CITY OF ALBUQUERQUE

December 8, 2014

**Re: Trapnell Orthodontics
Grading and Drainage Plan
Engineer's Date 11-25-14 (J09D022)**

CG-101

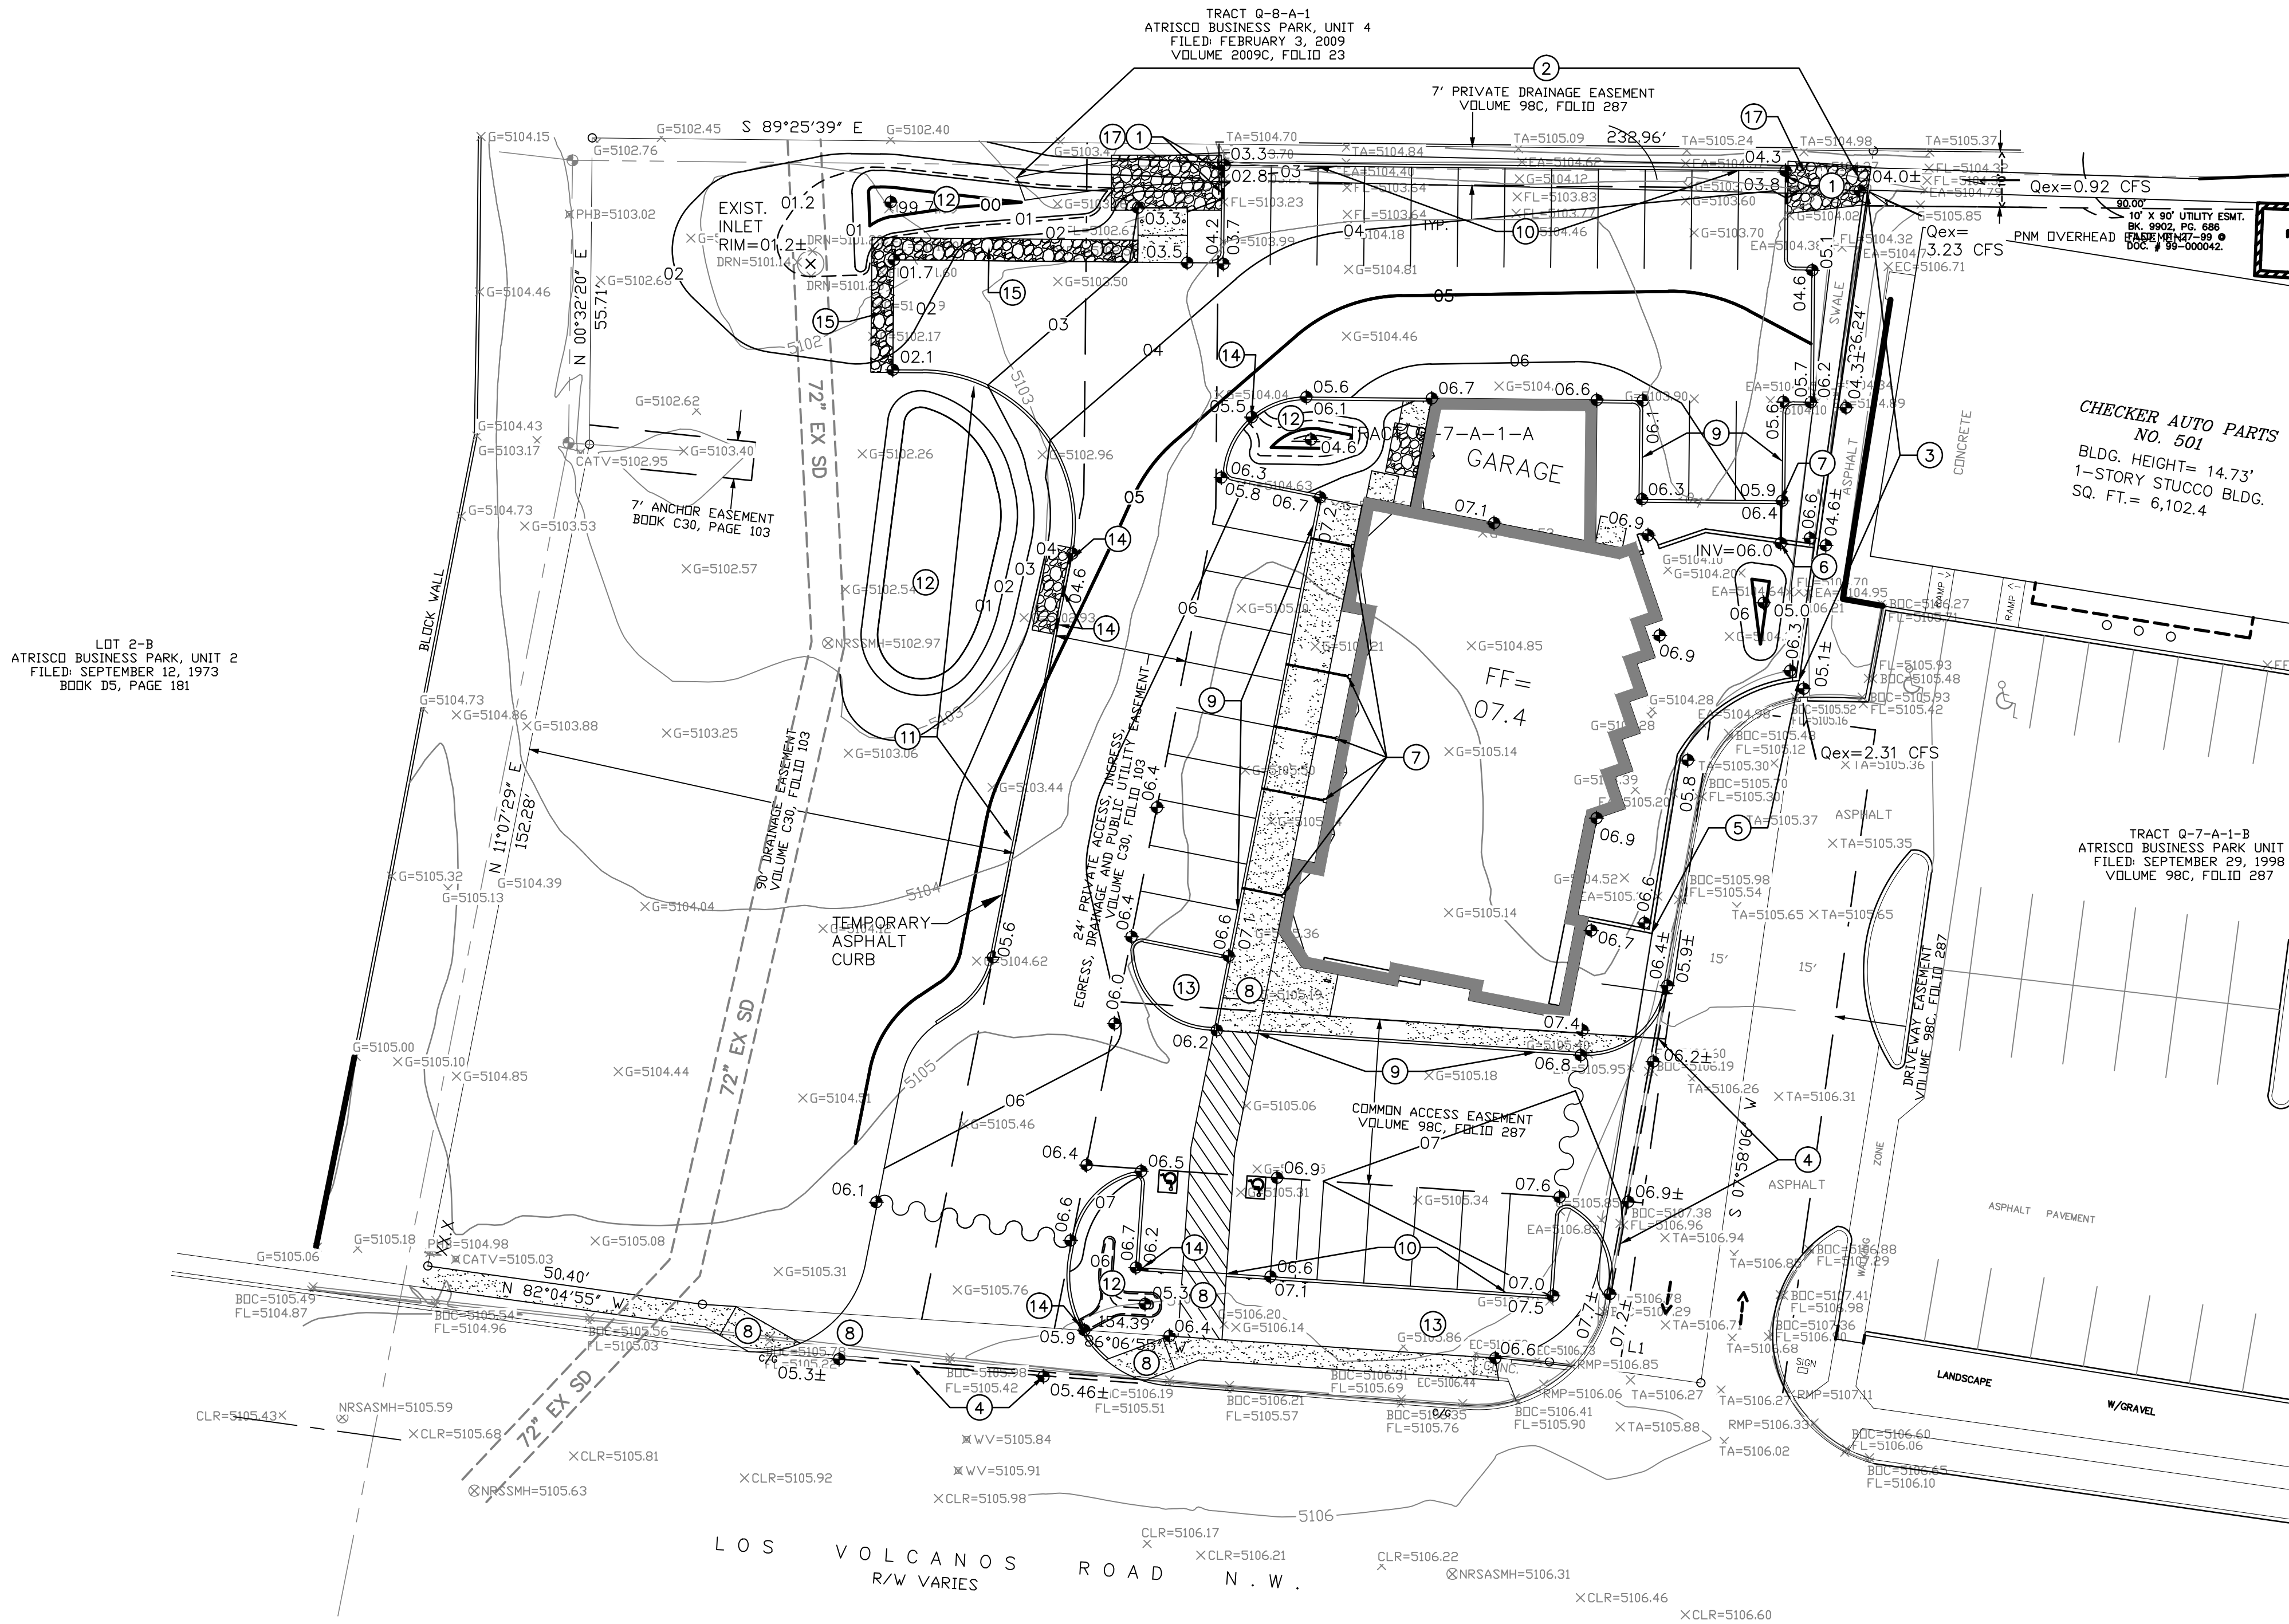
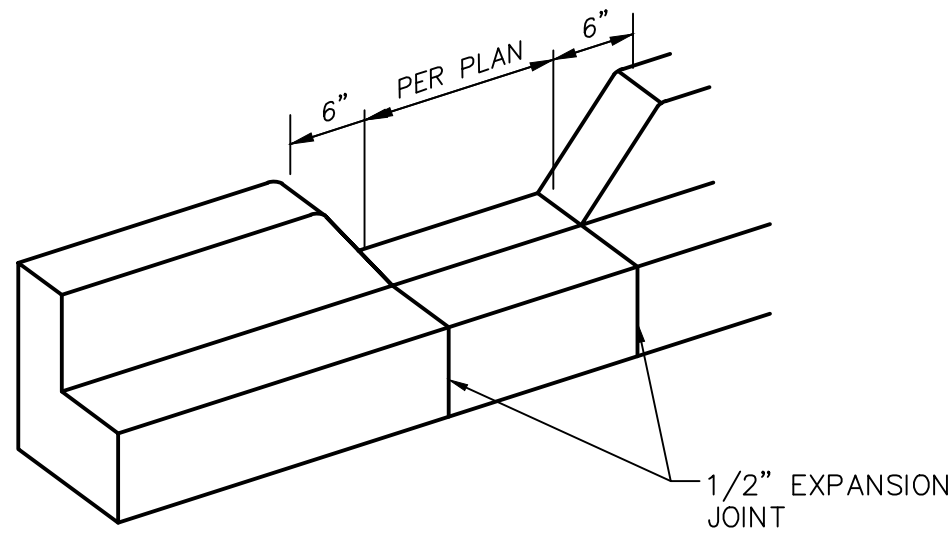
1. Provide the allowable amount of discharge into the on-site storm drain for this site as described in the Clifford West Business Park. Also include the amount for the Checker Auto site since the flows from that site are going through the Trapnell property. Show that the actual discharge is less than allowable amount and the pond is sized appropriately.
